City of Albuquerque

RE: ENGINEER'S CERTIFICATION FOR AIRBORNE (N-15/D1A5)\
RECEIVED OCTOBER 29, 1993 FOR CERTIFICATE OF OCCUPANCY APPROVAL
STAMPED & DATED 10-29-93

RE: DRAINAGE/GRADING PLAN FOR AIRBORNE; AIRPORT TECHNICAL CENTER
RECEIVED FEBRUARY 19, 1993 FOR BUILDING PERMIT APPROVAL
STAMPED & DATED 2-18-93; (N-15/D1A5)

AIRBORNE DRAINAGE / GRADING PLAN

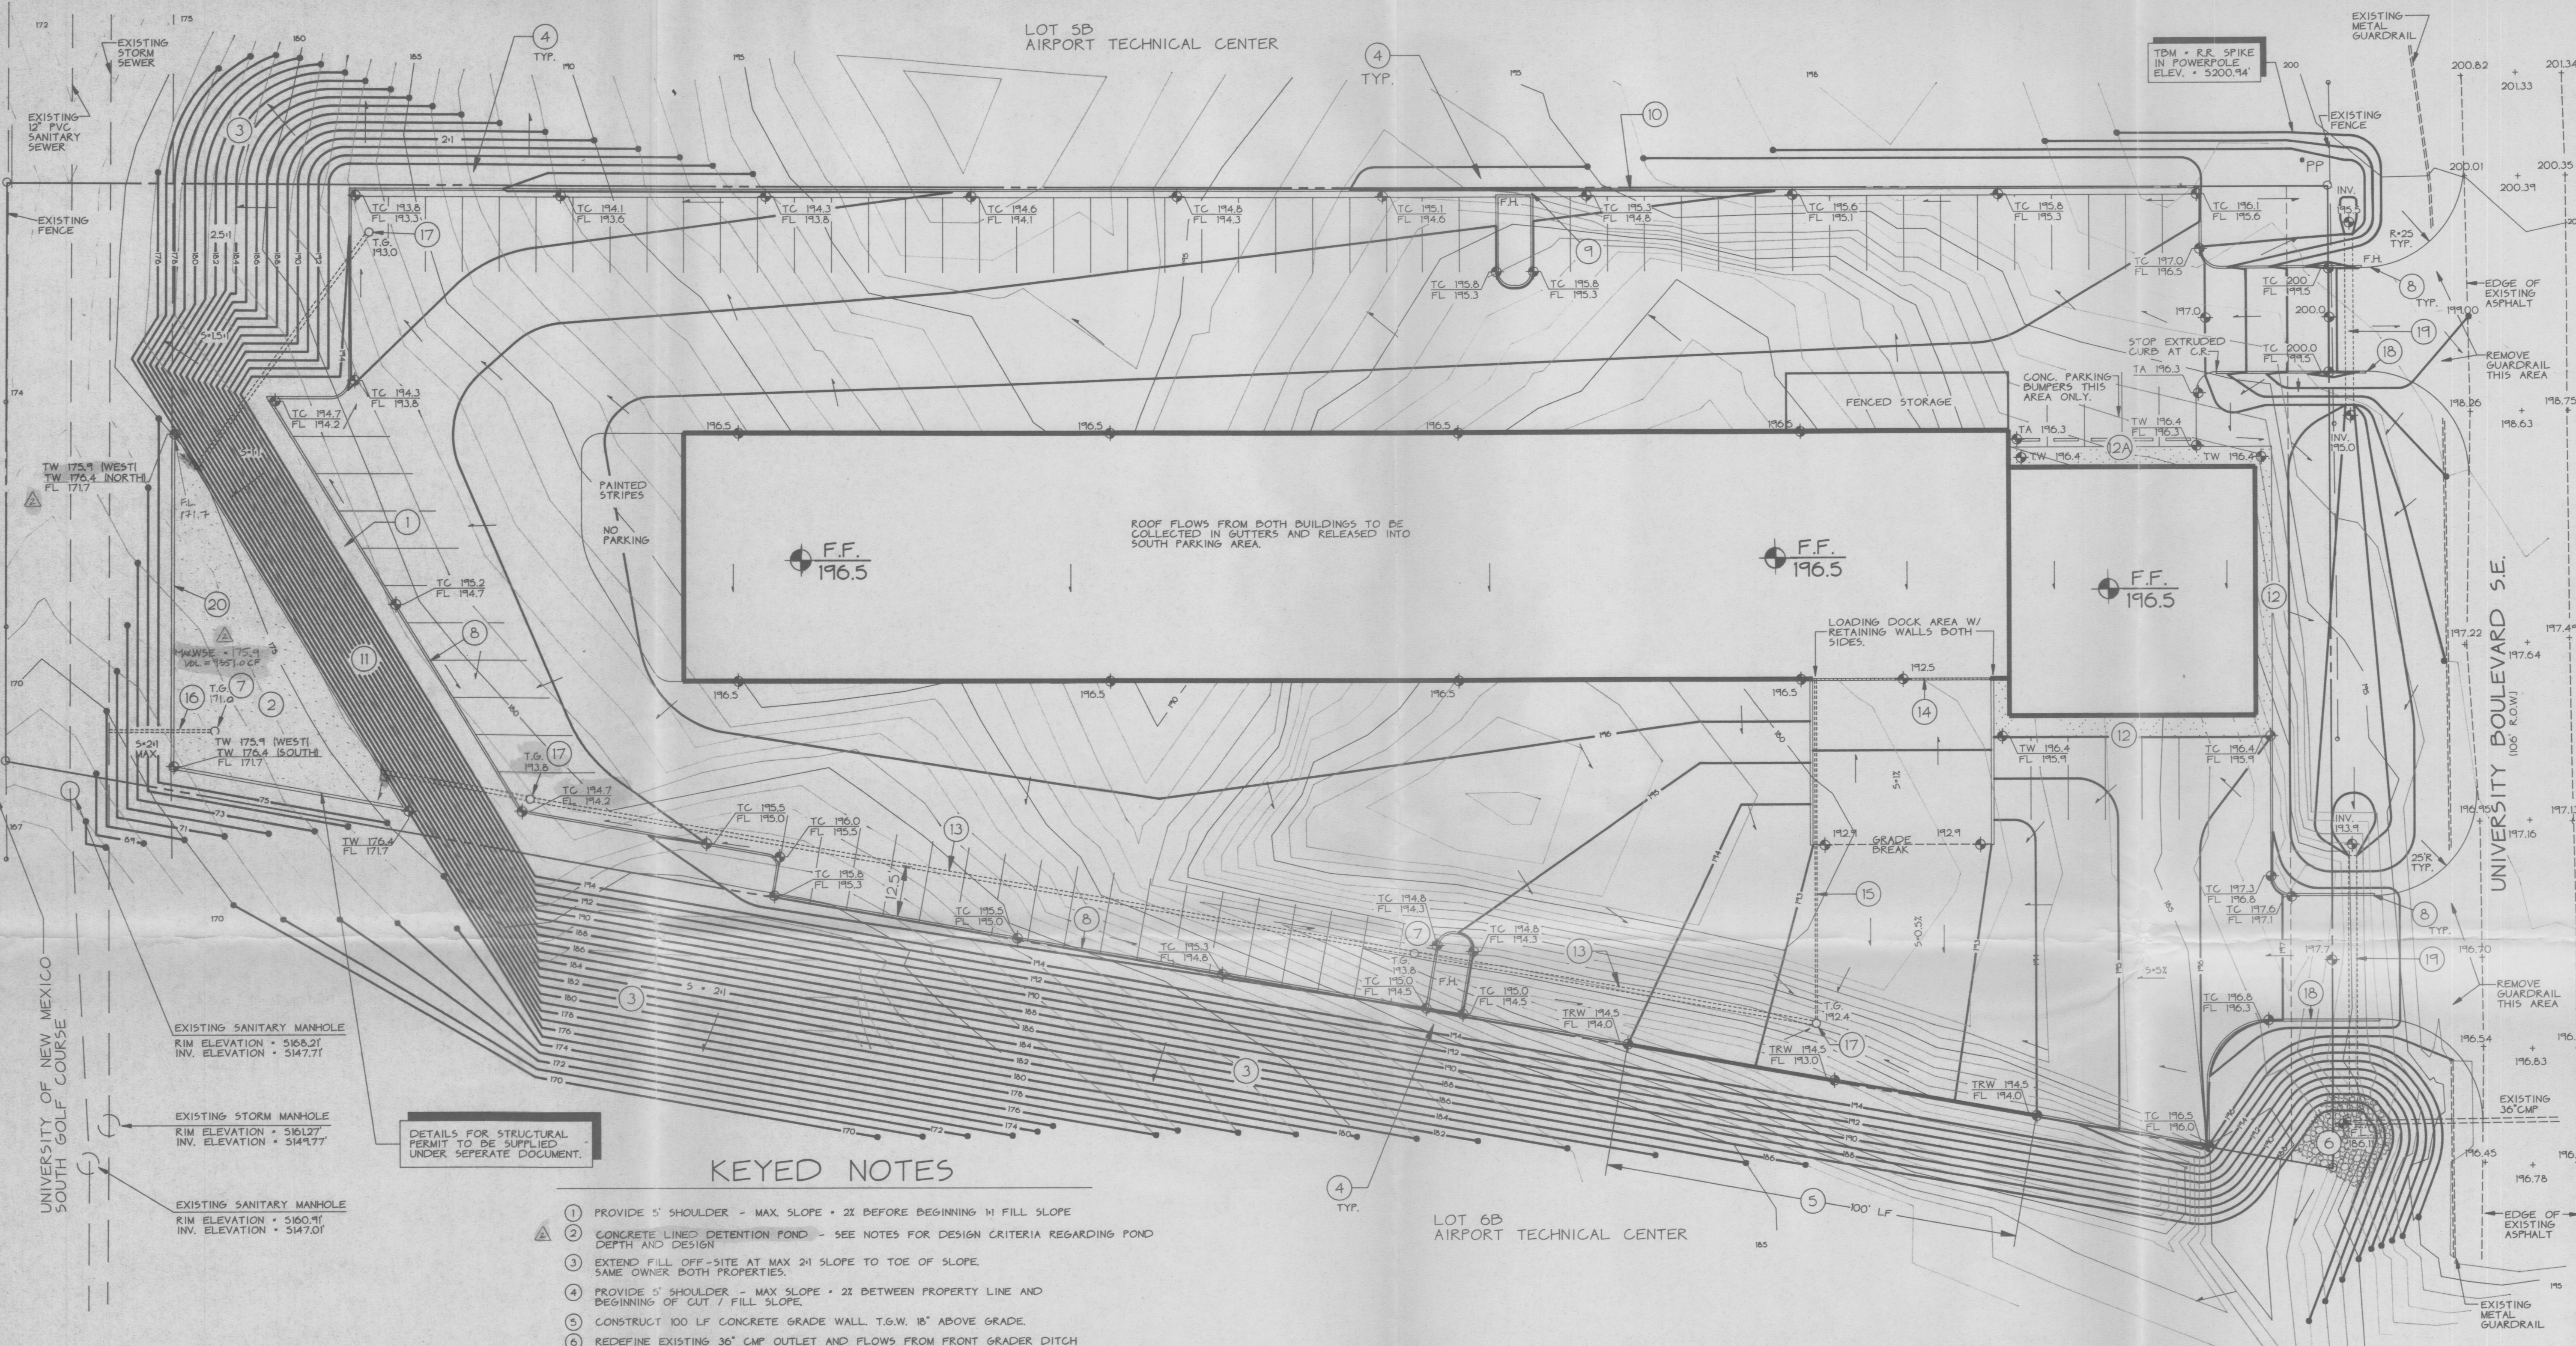
1. City Hydrology prefers to see the proposed elevation crossed out and the as-built elevations shown adjacent on the approved Plan. If it is necessary to have a separate As-Built, Then it must include sufficient information to tell how the Plan was modified.
2. Add a Legend of all symbols used. Each spot elevation needs to be identified as to what it is (Top of Curb, Top of Wall, etc). Include as-built Finished Floor elevations for both building areas. Provide as-built information for storm drain including manhole inverts. Indicate top & bottom limits of slopes. Add north arrow and indicate scale.
3. Spot elevation do not appear to indicate the required grade break at the North entrance.
4. Indicate how the new storm was connected to the existing.

9 NORTH STORM DRAIN PROFILE

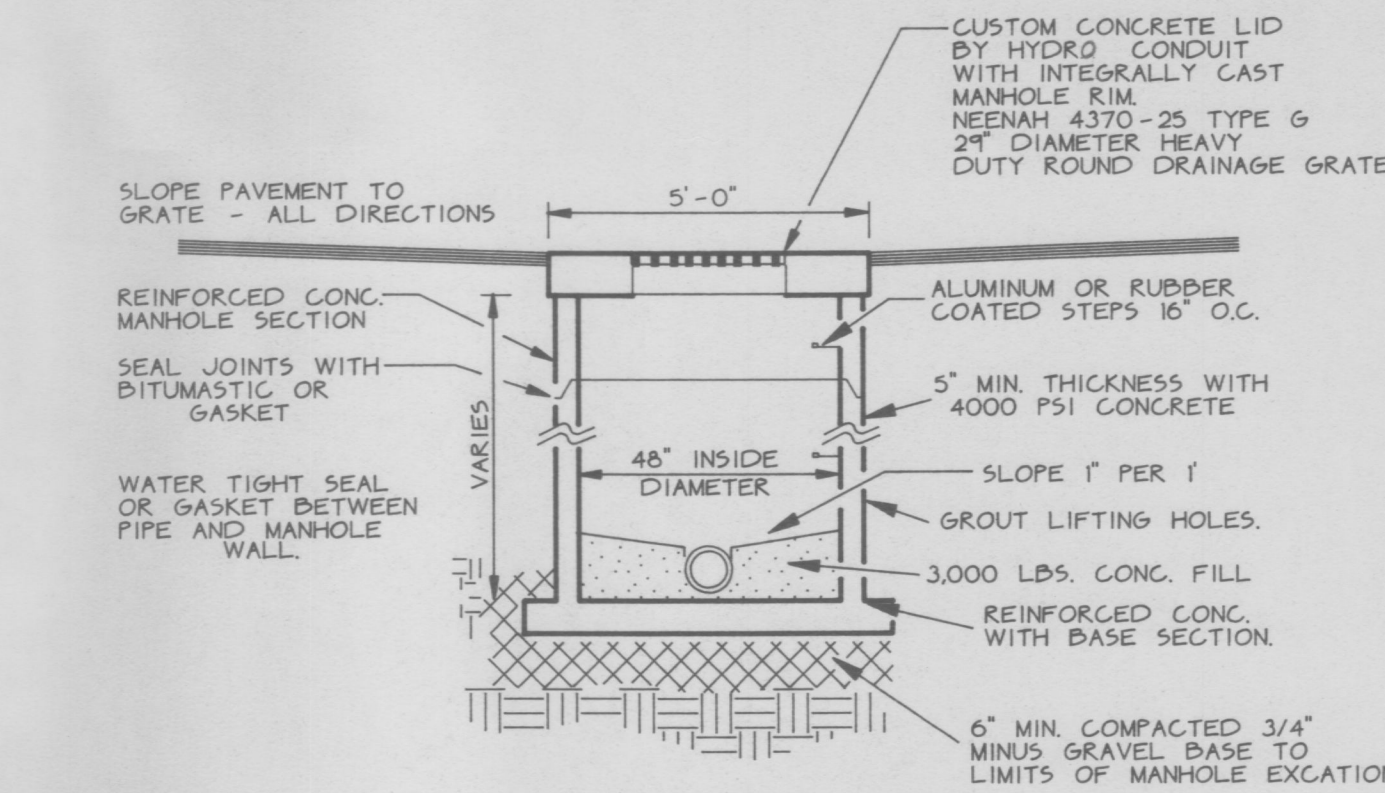
1. To be consistent, use a trapezoidal shaped hydrograph per section A.8 of Chapter 22.2. Indicate the values for t_c , t_p , t_b and $15*AD/AT$. Indicate volume of proposed detention pond and the Maximum Water Surface Elevation.
2. Indicate the flow rate and velocity for each segment on both storm drain profiles. What sort of energy dissipation is required at the inlet to the basin? It appears that the detention pond is a concrete box. This should be clearly stated.
3. How was the maximum discharge from this property determined? If 3.8cfs is the maximum then the discharge pipe will need to have an area less than .30 sf. Rather than use a smaller pipe, an orifice plate could be installed.
